BOTLEY WEST SOLAR FARM

OXFORDSHIRE HOST AUTHORITIES RESPONSES FOR DEADLINE 5 | FRIDAY 12 SEPTEMBER 2025

The purpose of this submission is to provide written confirmation of the OHA’s comments and response on documents submitted at Deadline 4 (**D4**), responses to Second Written Questions (**ExQ2**). The written comments provided below do not prejudice the OHA’s ability to make further comments on these matters.

- Order Limits:
- Cable Corridor:
- Cable Corridor Option:
- Indicative HDD Entry / Exit Pit:

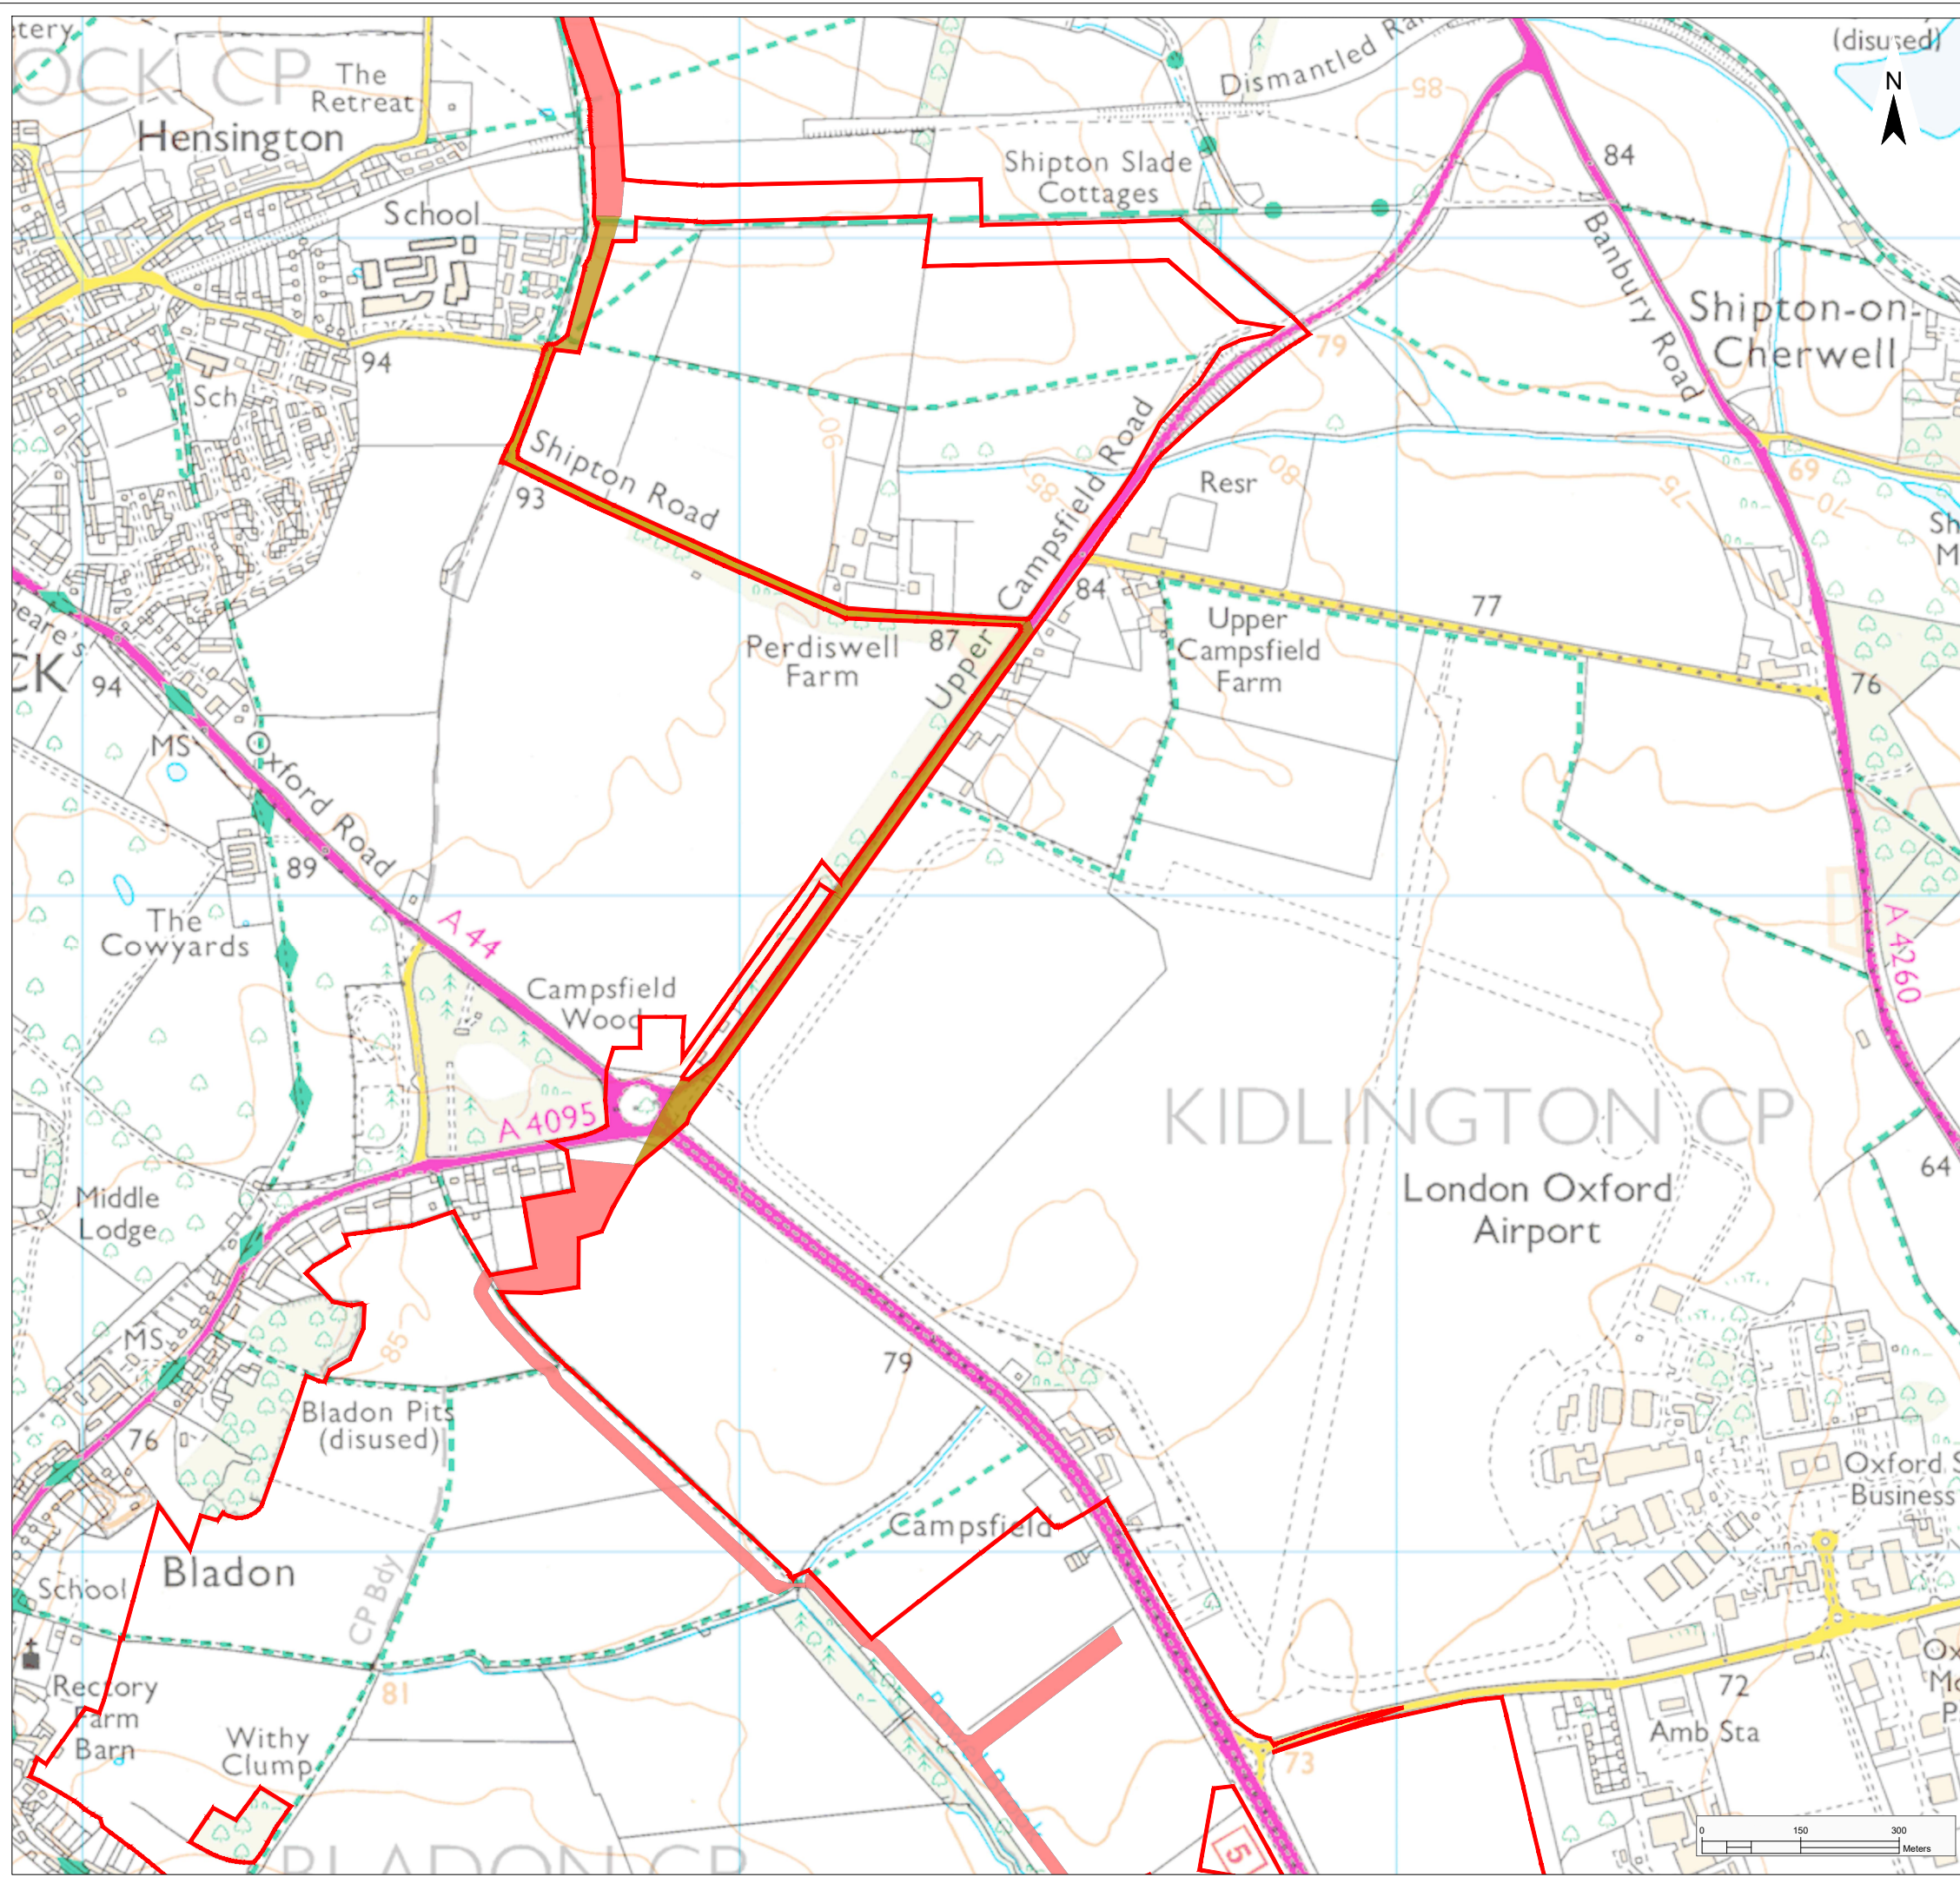
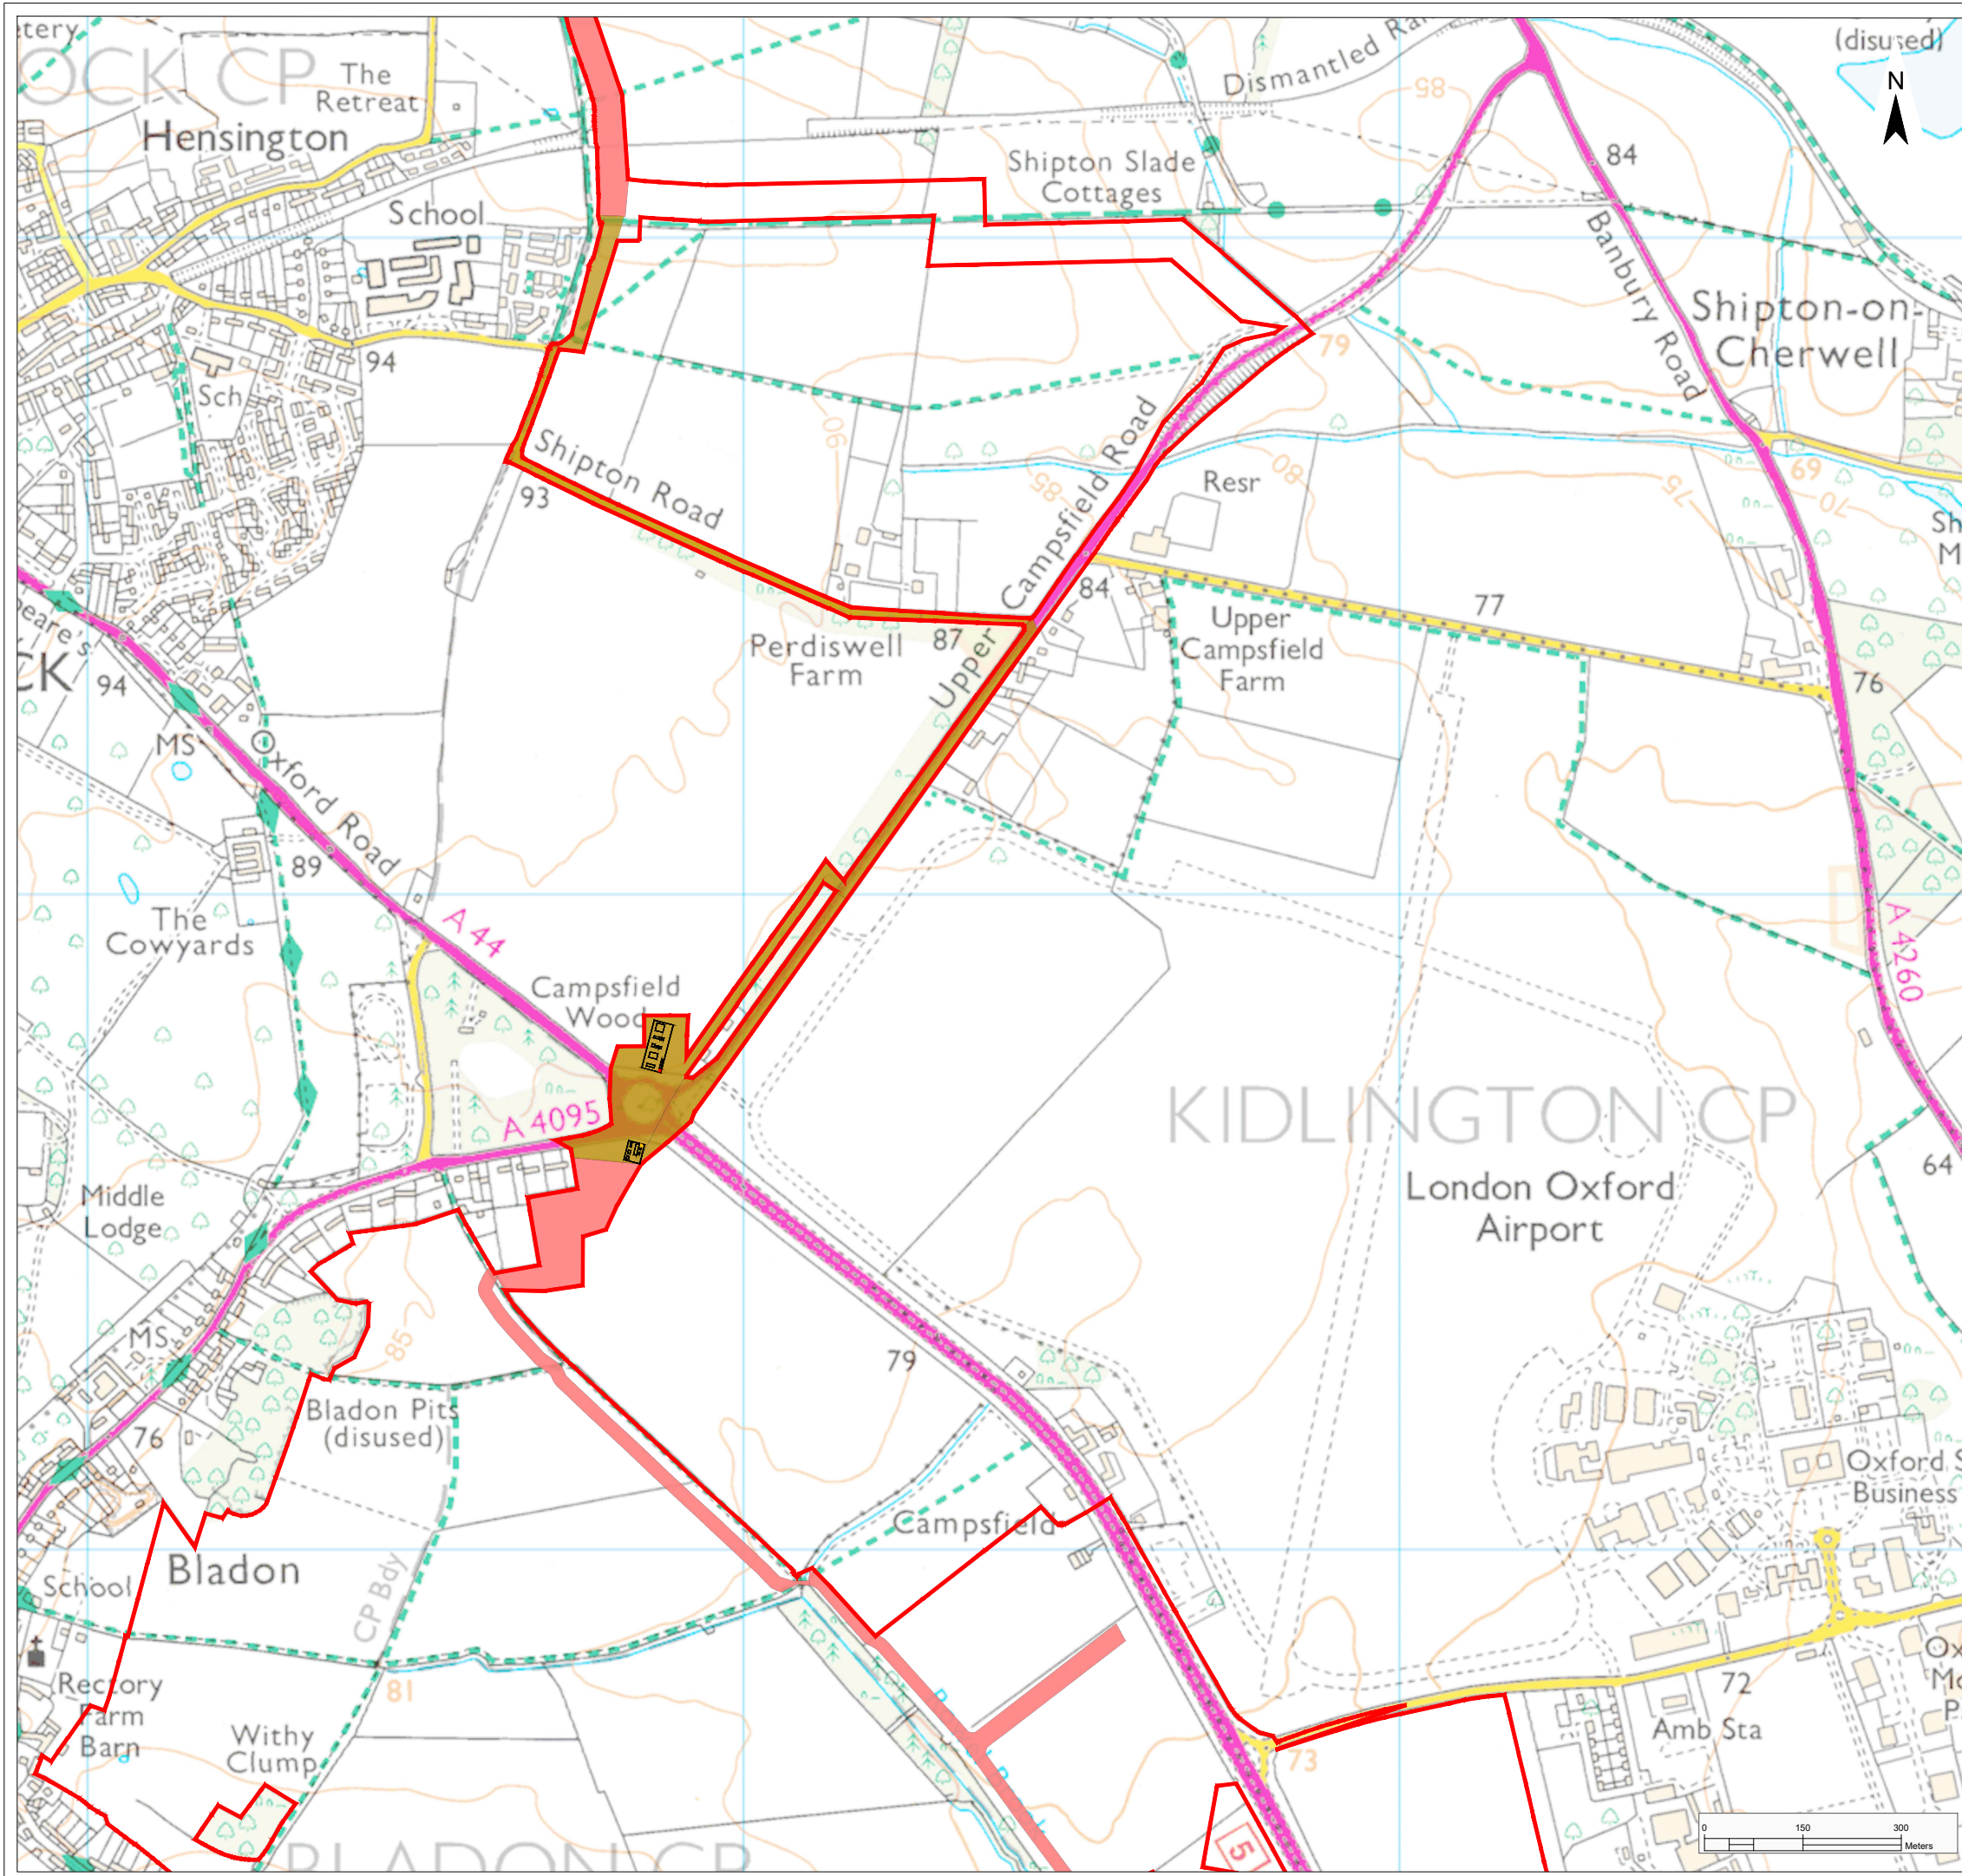
<p>At 2.3.5 of the report, it states that ‘<i>This cable corridor follows the eastern perimeter of Bladon Heath, avoiding direct woodland intrusion but passing close to several ecological and arboricultural features, including mature trees, hedgerows, and a veteran tree protected under BS 5837 and the NPPF. To avoid trenching within the tree’s root protection zone (RPZ), a Horizontal Directional Drilling (HDD) section may be required; the final decision on HDD use will be made in consultation with OCC.</i></p> <p>However, without the detailed arboricultural survey and an updated detailed arboricultural impact assessment, an accurate assessment of the route of this cabling on the arboricultural features including a veteran tree cannot be made.</p> <p>The applicant is reminded of the following standing advice: ‘For ancient or veteran trees (including those on the woodland boundary), the buffer zone should be at least 15 times larger than the diameter of the tree. The buffer zone should be 5 metres from the edge of the tree’s canopy if that area is larger than 15 times the tree’s diameter. This will create a minimum root protection area’ (https://www.gov.uk/guidance/ancient-woodland-ancient-trees-and-veteran-trees-advice-for-making-planning-decisions#avoid-impacts-reduce-mitigate-impacts-and-compensate-as-a-last-resort).</p> <p>OCAS comments on cable routes</p> <p>Cable Optionality Area 1 - Northern Site between the Oxfordshire Way, and B4027, south east of Wootton</p> <p>The area proposed by these two options were not assessed by the archaeological evaluations of the proposal. There are however located in an area of considerable archaeological interest with both options running alongside the Witney Ridgeway, recorded as Grundy’s Road 3 and called Heh Street in the Shipton on Cherwell charted od AD 1005. Both options also cross the known line of Akeman Street, the Roman Road from Alchester to Cirencester. In addition, two parallel linear features have been recorded from aerial photographs from 1961 200m NE of these proposed cable routes. These features have been recorded as a possible Neolithic Cursus monument although a</p>

<p>re-examination of the photographs does suggest they are likely to be a pre-medieval trackway, a continuation of which would cross the line of these proposed cable options.</p> <p>As such we cannot agree with the assessment in this document (EN010147) which states that no heritage assets would be affected. This area would need to be subject to further evaluation and mitigation, including preservation in situ of any significant remains as set out in the submitted overarching written scheme of investigation.</p> <p>Cable Optionality Area 2 - Area between the Northern and Central Sites on land to the east of Woodstock and in the vicinity of the Bladon roundabout on the A44</p> <p>Option 1 – This area was not subject to the archaeological evaluation and as such the archaeological potential of the site is unknown. The proposed route is however located in an area of archaeological interest and an area of prehistoric settlement has been recorded adjacent to the southern part of this option (HER PRN 28571). This route option therefore has the potential to impact archaeological features related to this settlement and to impact previously unrecorded archaeological deposits along the route.</p> <p>Option 2 – this proposed route also has the potential to impact on the area of prehistoric settlement recorded adjacent to its southern end. The section along Shipton Road also runs immediately north of archaeological features (HER PRN 28750), identified from a geophysical survey and trenched evaluation undertaken as part of a housing application which form a continuation of the scheduled Blenheim Villa (SM 35545).</p> <p>As such we cannot agree with the assessment in this document (EN010147) which states that no heritage assets would be affected. This area would need to be subject to further evaluation and mitigation, including preservation in situ of any significant remains as set out in the submitted overarching written scheme of investigation.</p>
